CITY OF PORTLAND BUILDING PERMIT

50 INDUSTRIAL WAY

PERMIT ID: 2012-65655

has permission to **installing a commercial fire alarm system.**

1 FIRST FLOOR NEW ADDITION CODE COMPLIANCE PLANS
SCALE: 1/8" = 1'-0"

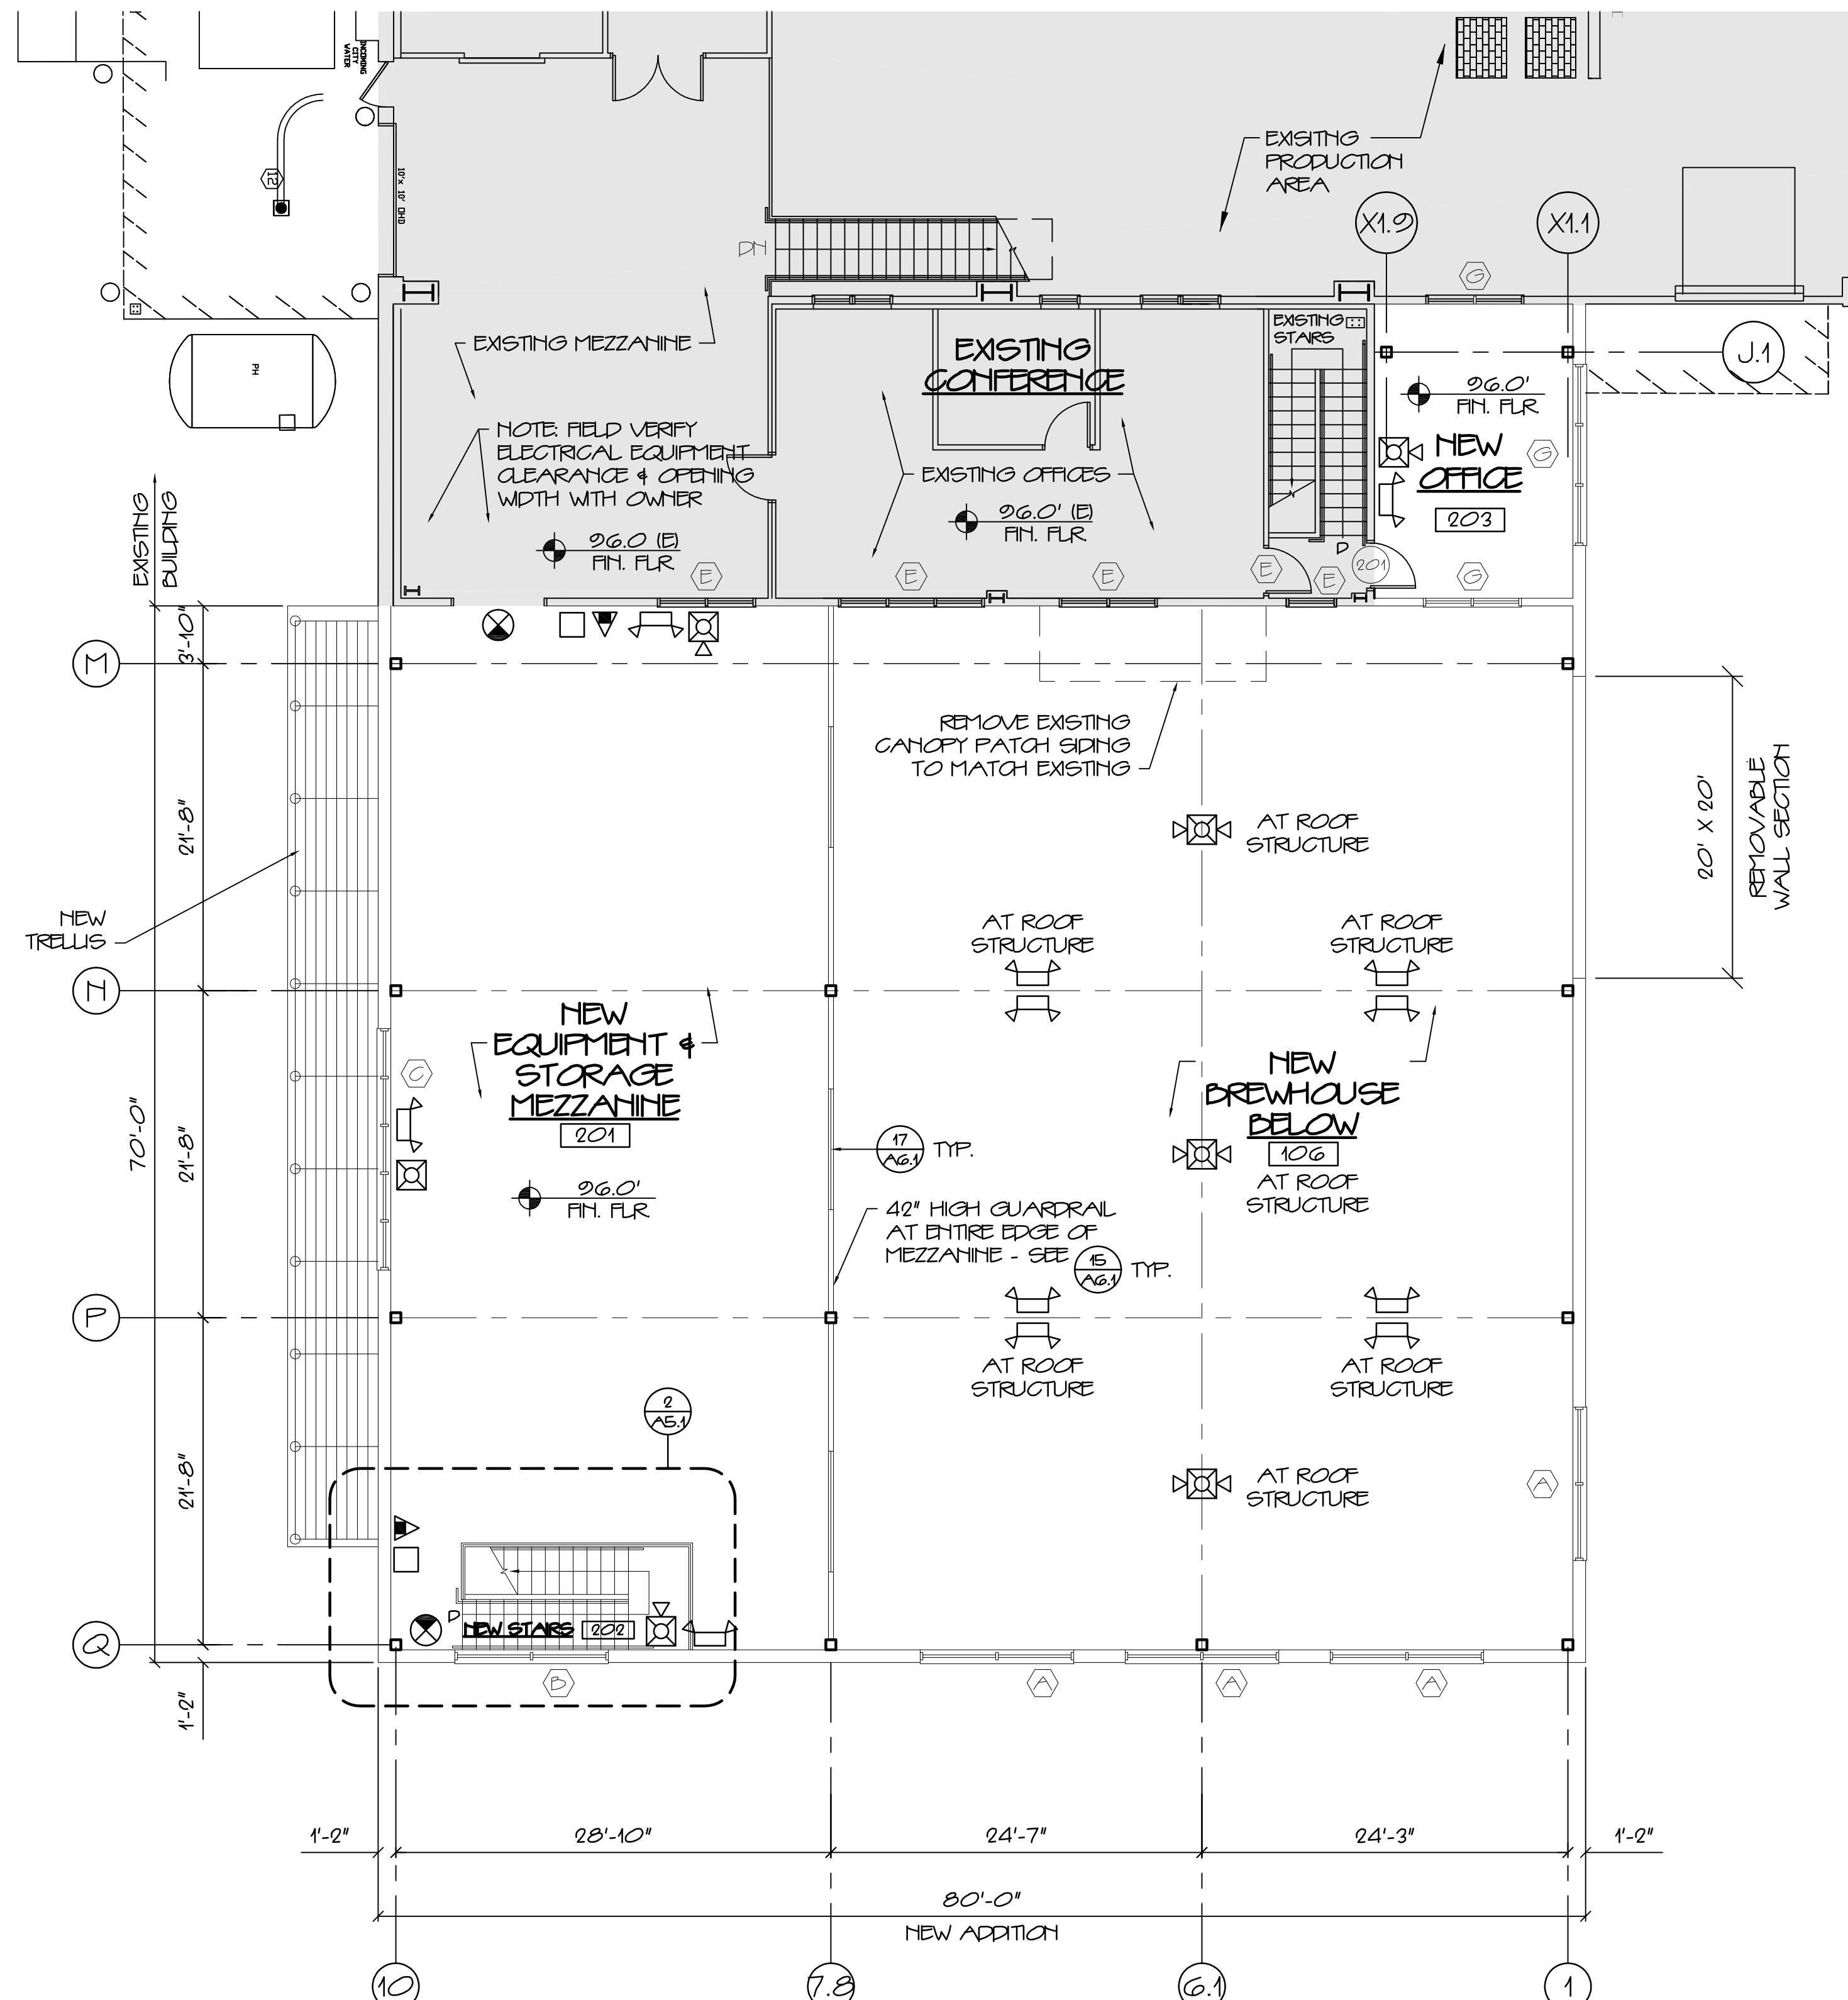
- 10) Visible signals are required per NFPA 101:9.6.3.5 in accordance with NFPA 72:18.5.4.4. Ceiling mounted strobes shall not exceed 30 ft above finish floor.

The a/v's in the stairwell, office, men's room and women's room will be 15 candela
The a/v's in the retail area and equipment storage will be 30 candela
The a/v's in the brewhouse (ceiling mount) will be 100 candela.

I copied the rep from Corey Electric to make sure he knows you requested that the ceiling mount horn strobes be mounted no higher than 30ft per code.
